**BOTLEY WEST SOLAR FARM**  
**OXFORDSHIRE HOST AUTHORITIES**  
**RESPONSE TO CHANGE REQUEST 2**  
**DEADLINE 6 | MONDAY 20 OCTOBER 2025**

Botley West Solar Farm (EN01014)

The purpose of this submission is to provide written confirmation of OHA responses to Change Request 2 (**CR2**).

Single frame illustrative Summer Year 15: Viewpoint 48
Figure 8.359

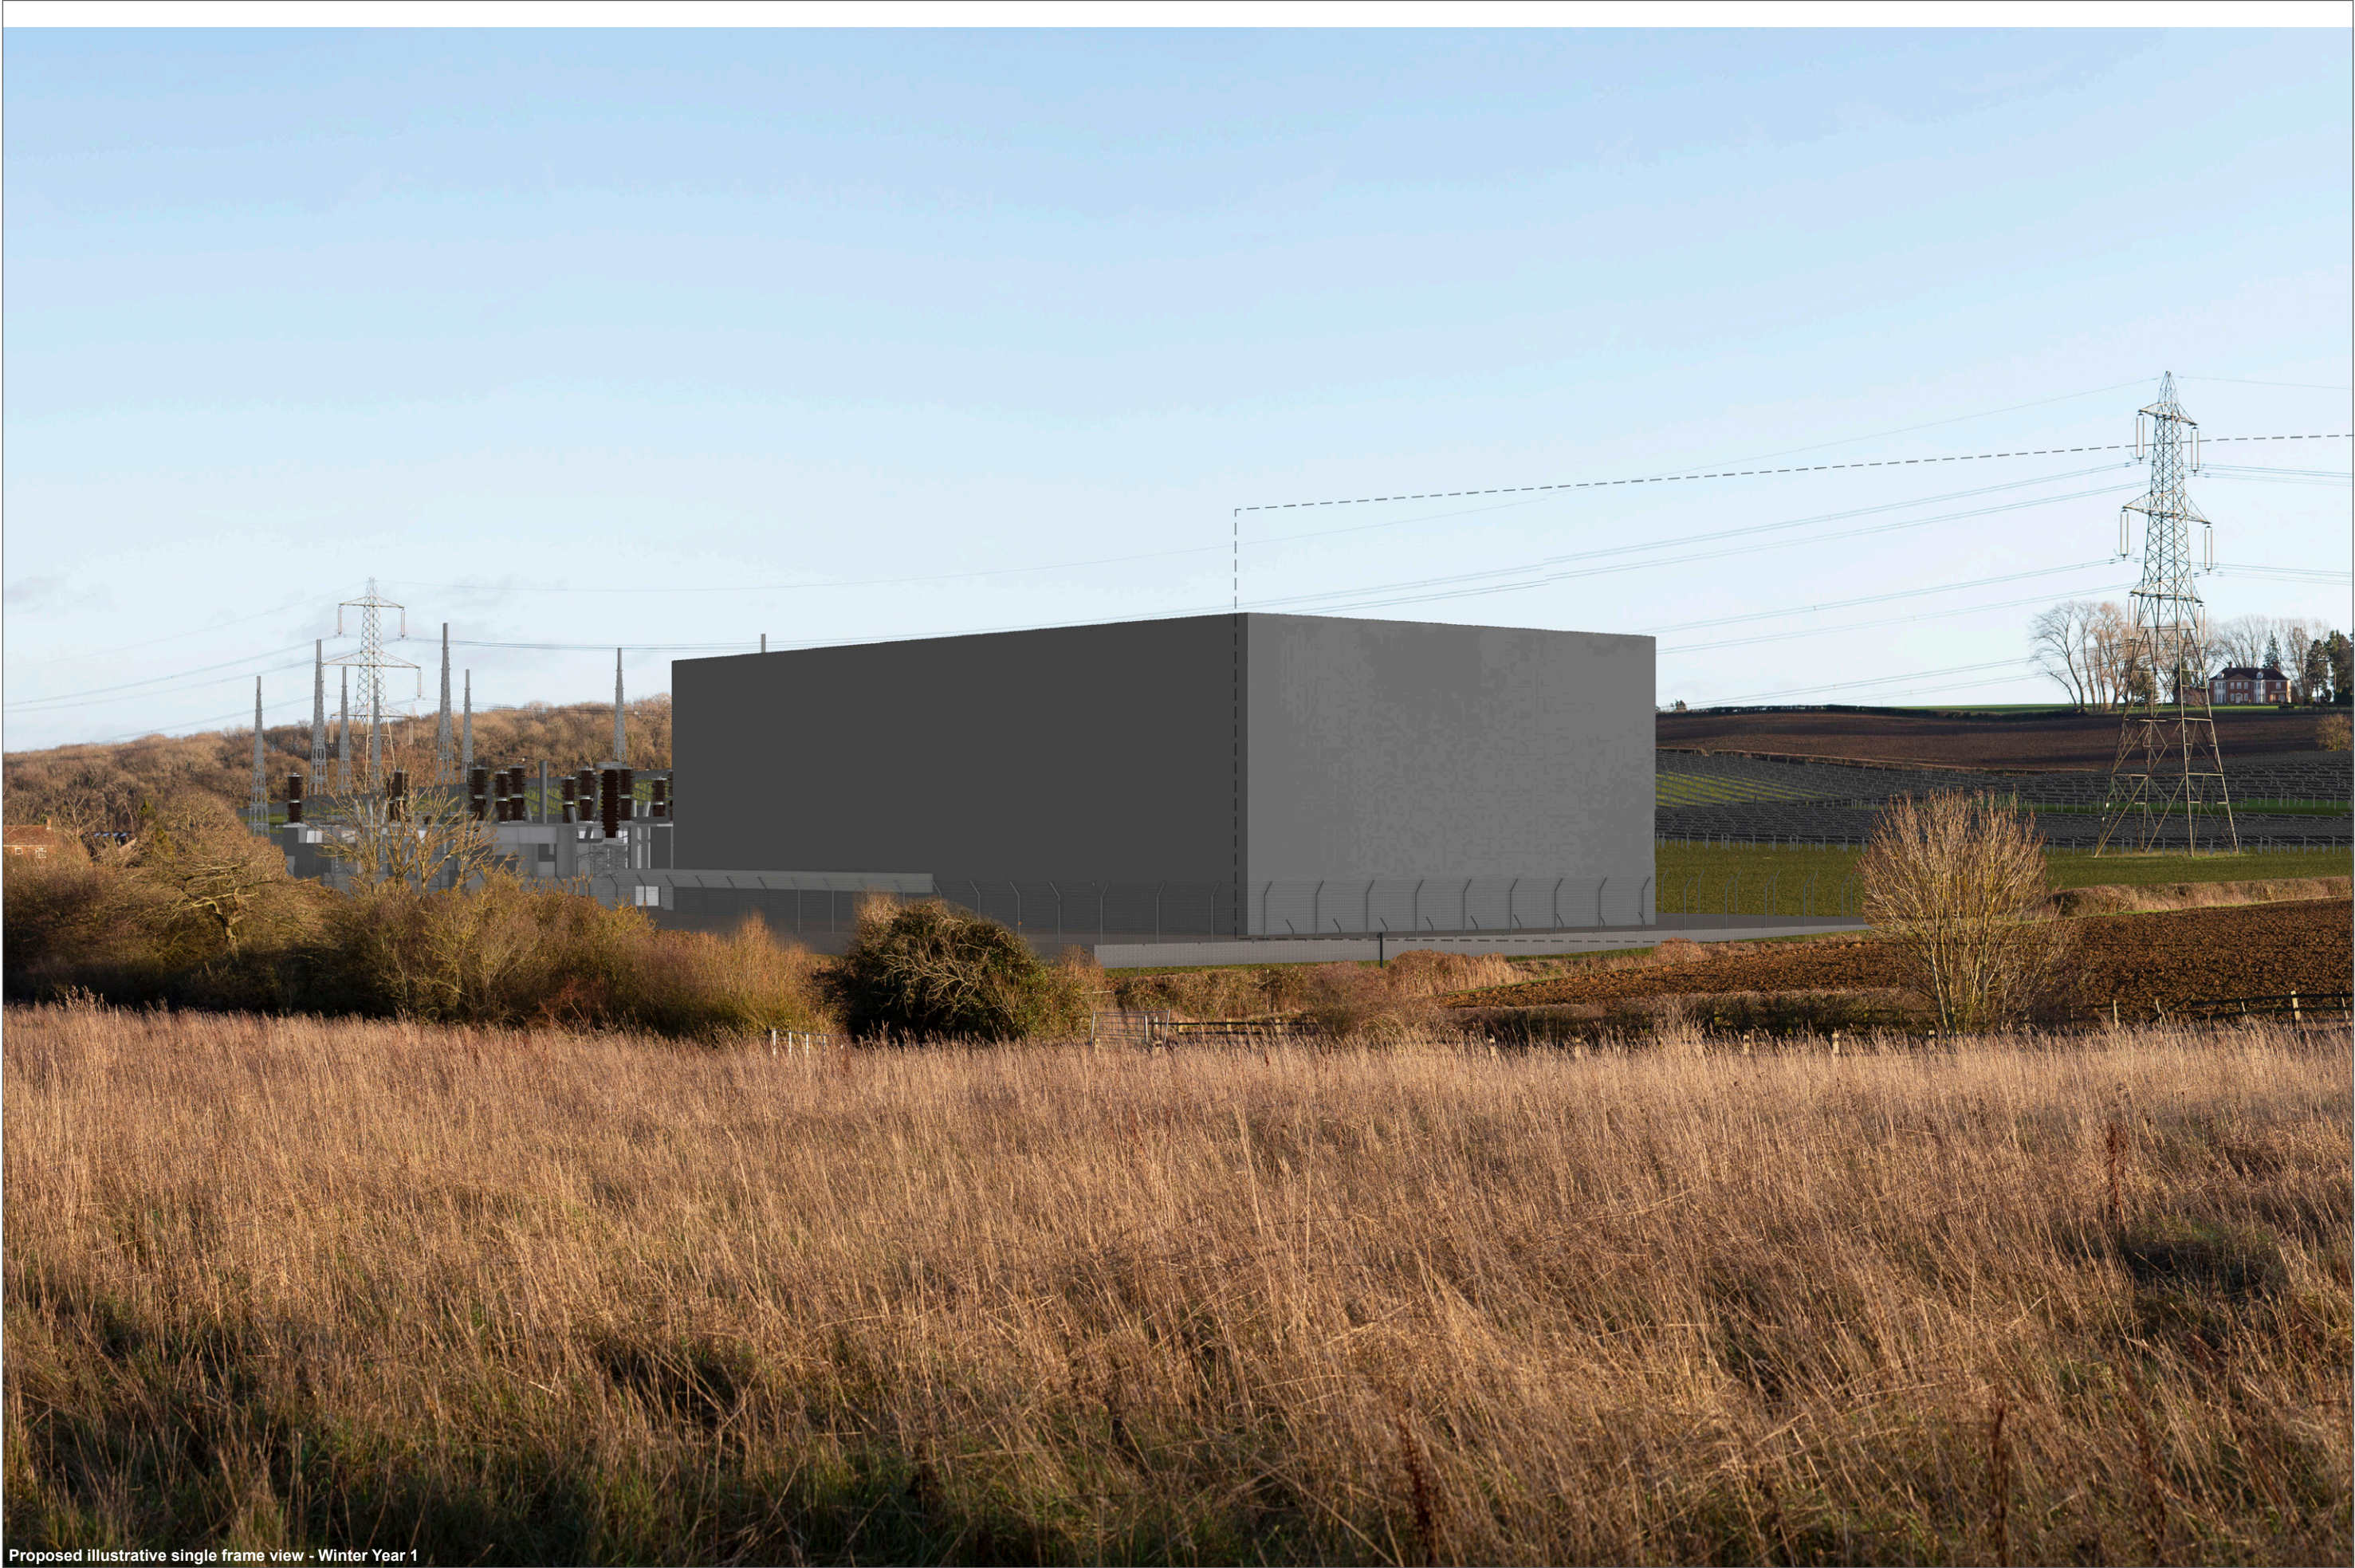
For example, the assessment for Viewpoint 48 during Construction is recorded in Para 1.2.51 as **Medium** Magnitude of change resulting in a temporary **Moderate** adverse level of effect which is considered significant. During Occupation (para 1.3.98) Year 1 reports a **High** Magnitude, resulting in a **Major** adverse level of effect, which would be considered significant. At summer Year 15 (para 1.3.99), a **Medium-High** Magnitude of effect is reported, resulting in a **Moderate/Major** adverse level of effect, which is considered significant.

This however is recorded differently in Table 8.22: Summary of potential environmental effects. In the Table, Viewpoint 48 has a **Medium** Magnitude of effect for both Construction and a **Low** Magnitude of effect for Operation, giving a **Moderate** level of effect at Year 1 and a **Minor** level of effect at year 15 for both Construction and Operation.

Assumed location of National Grid Electricity
Transmission (NGET) Substation

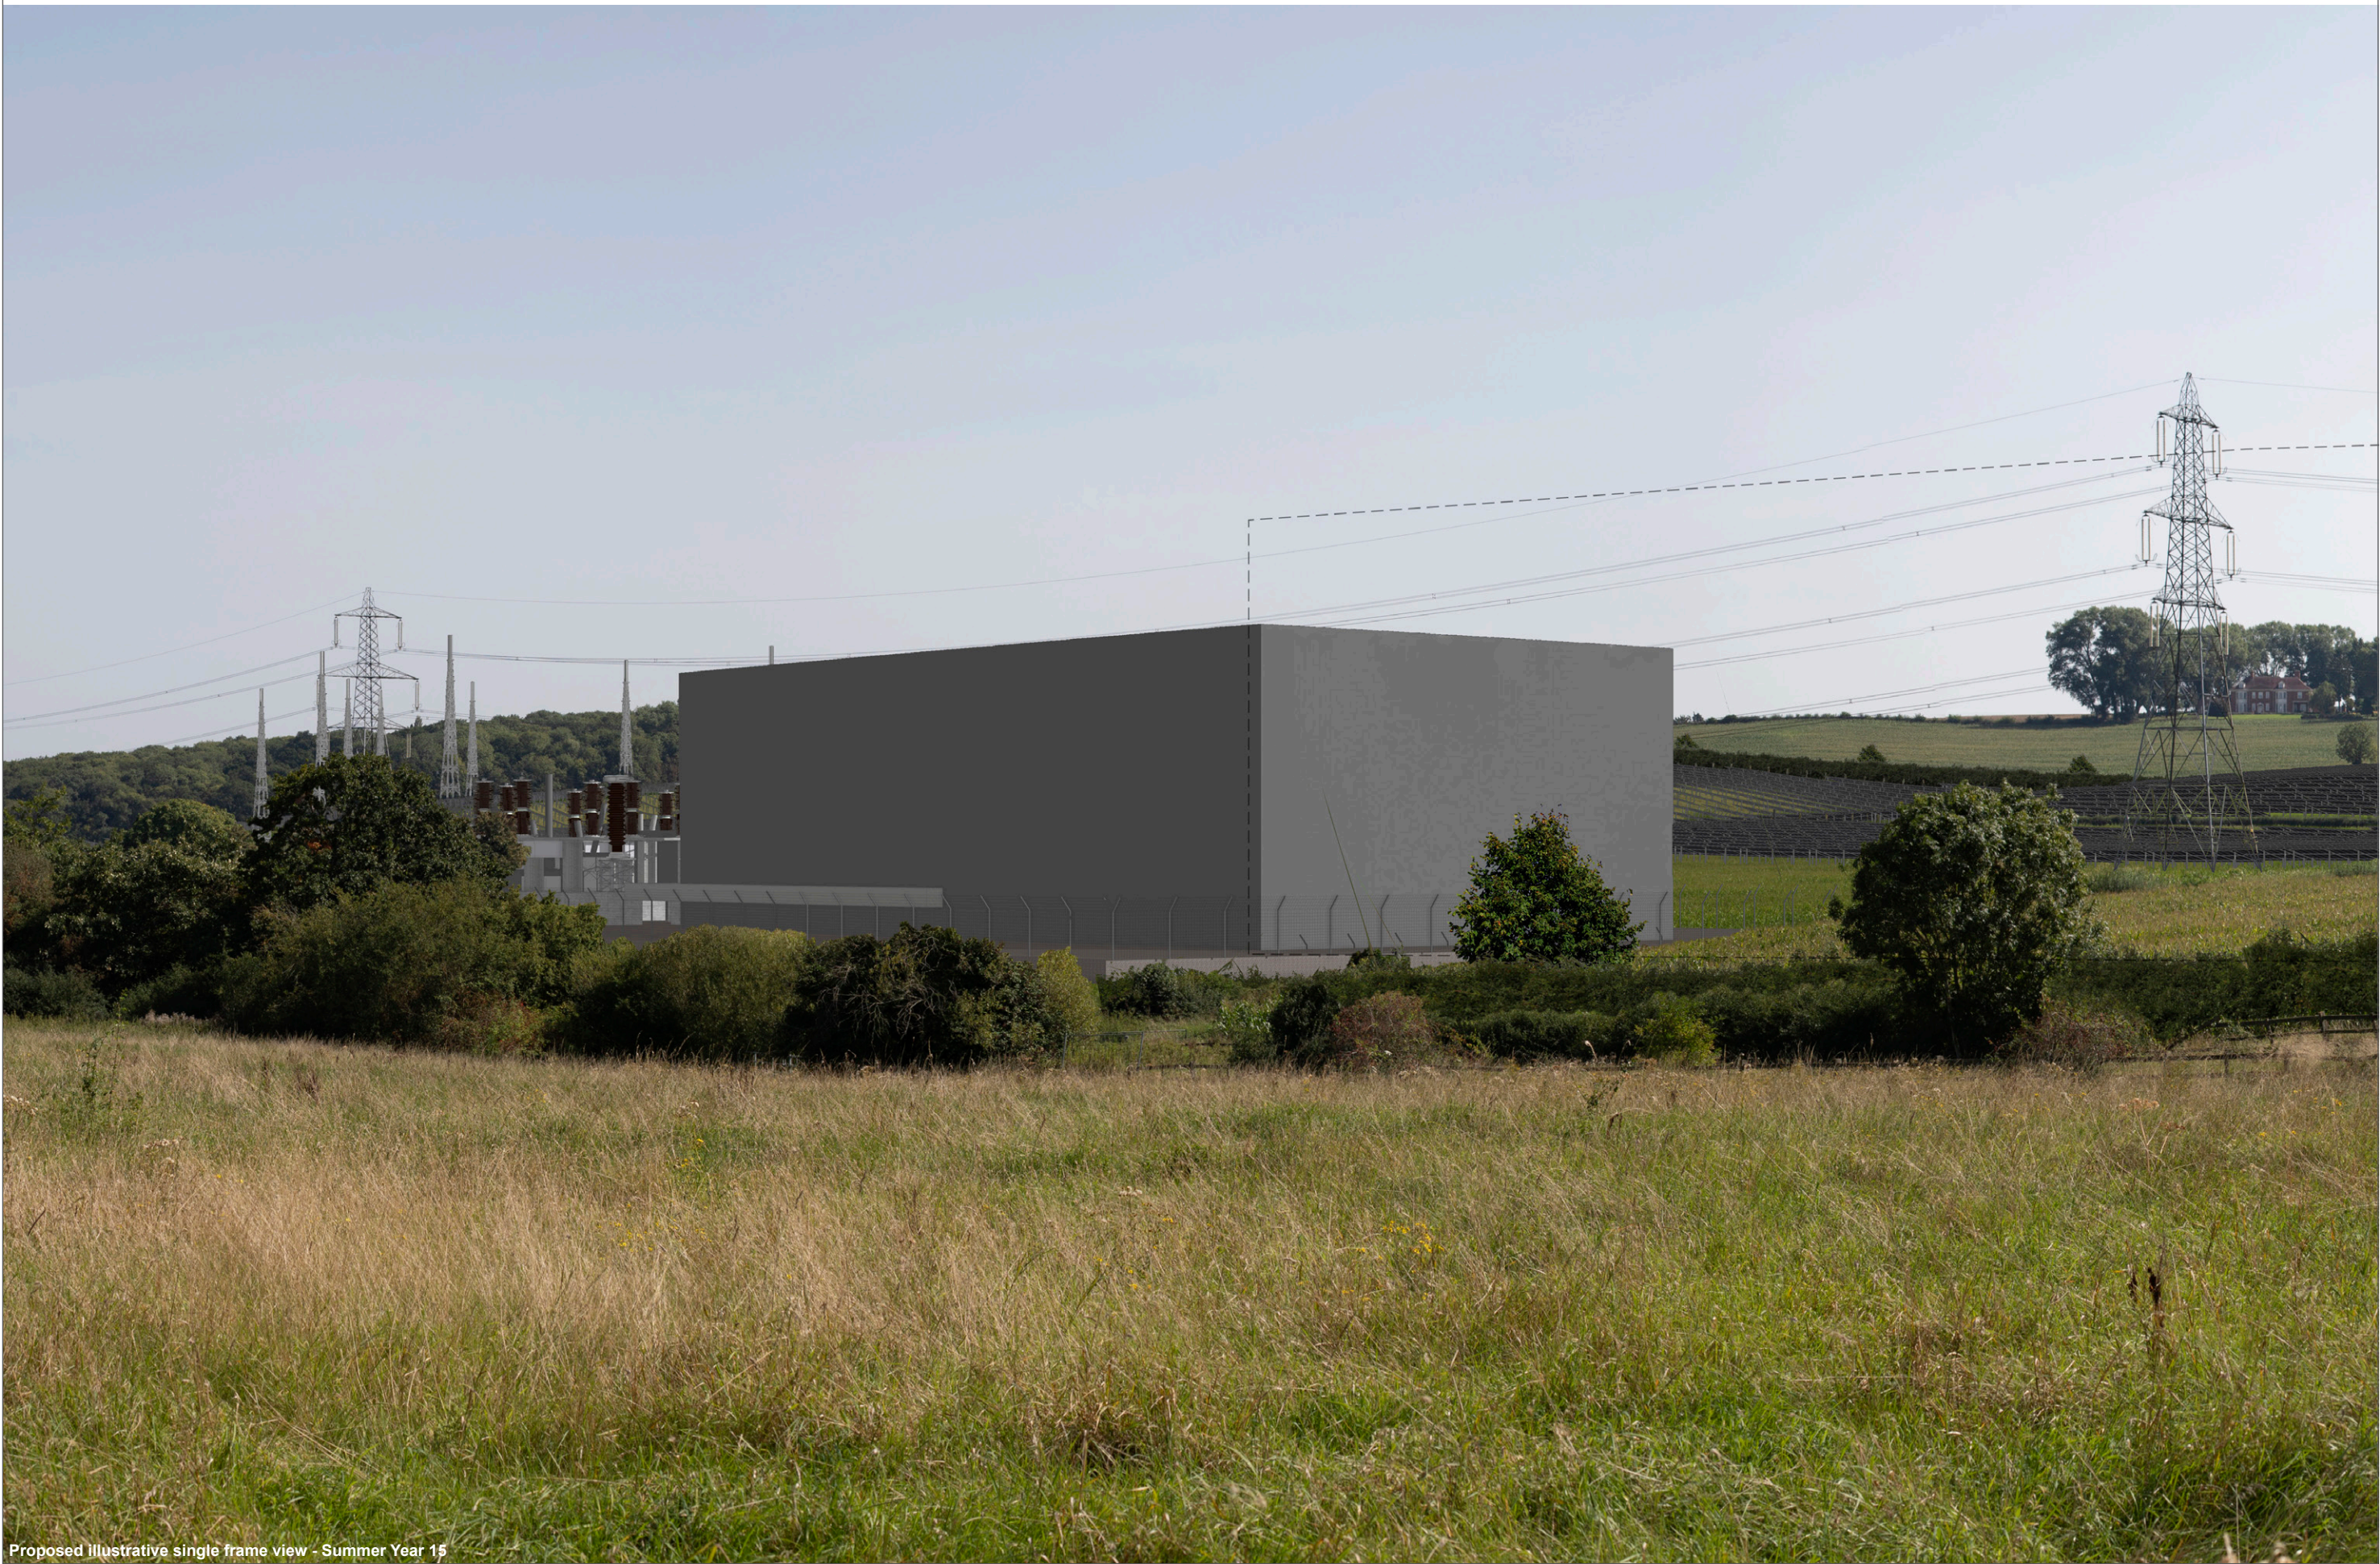
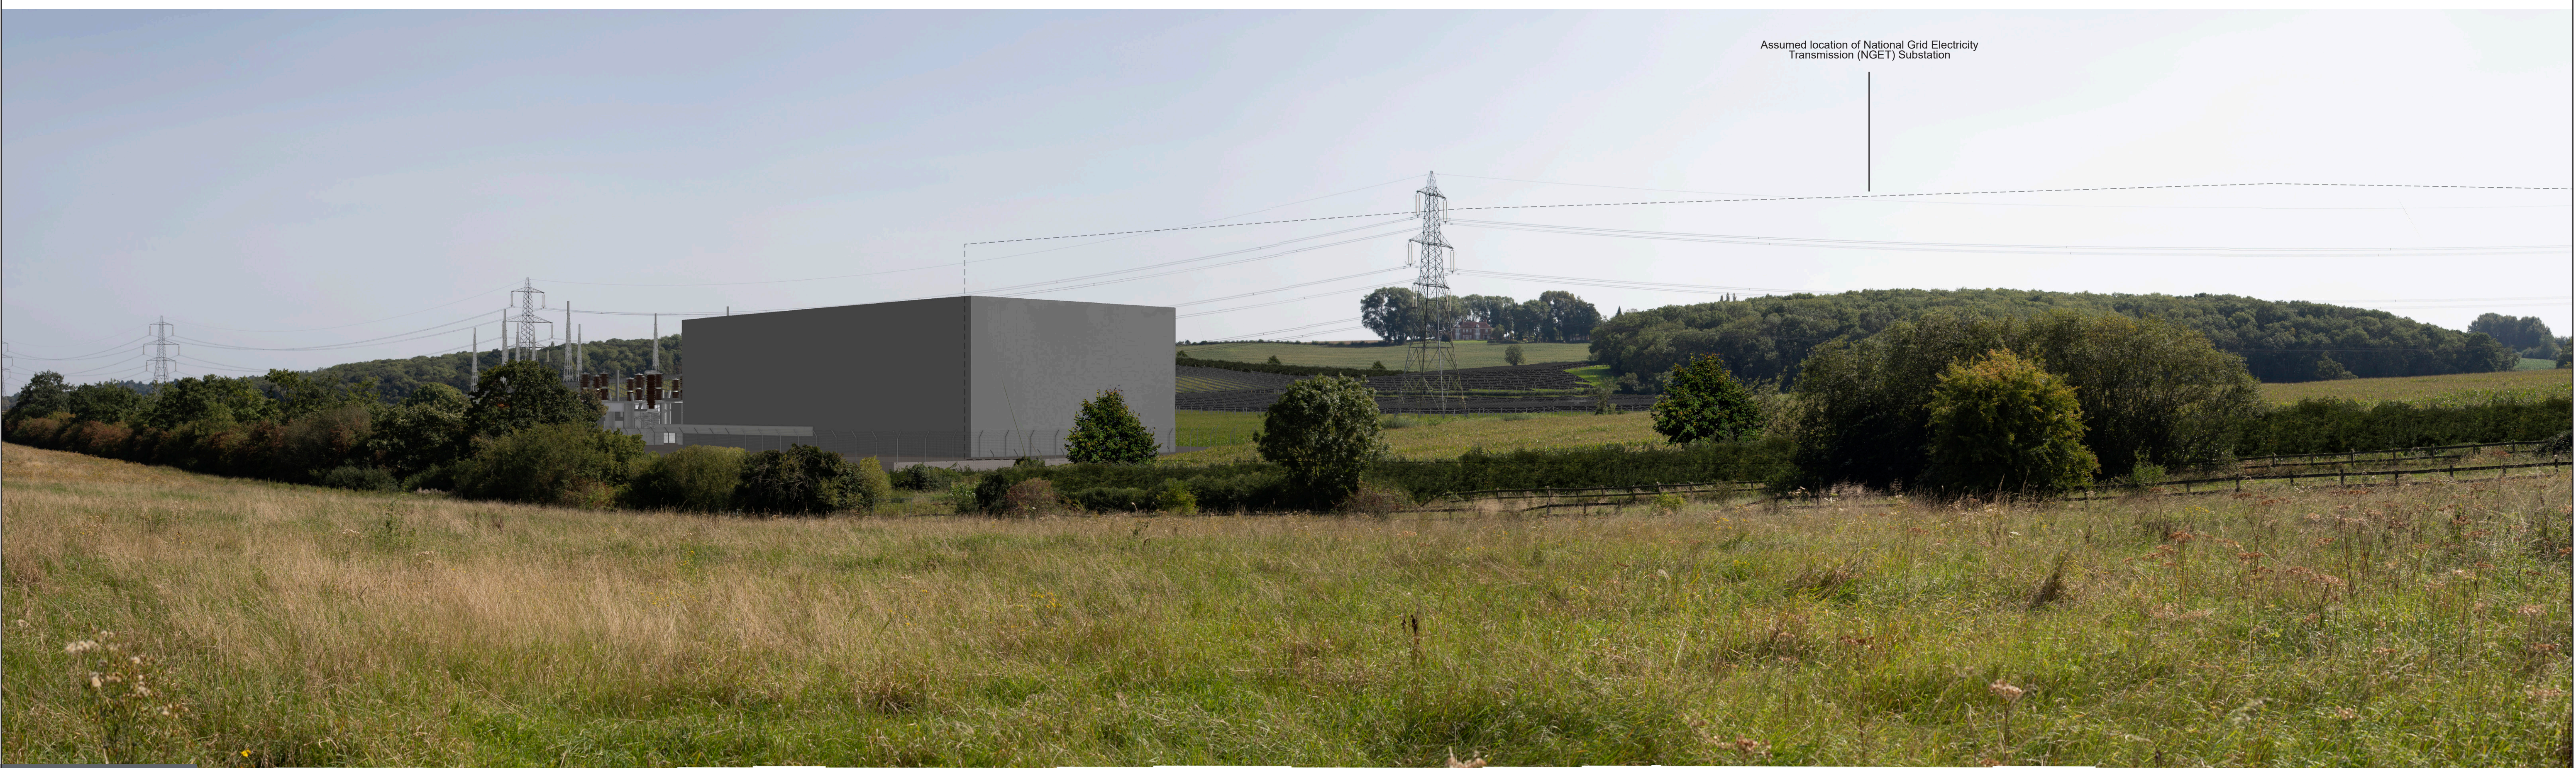
This document does not indicate that there has been any change in the Photomontages to reflect the changes in the height and massing of the NGET Substation.
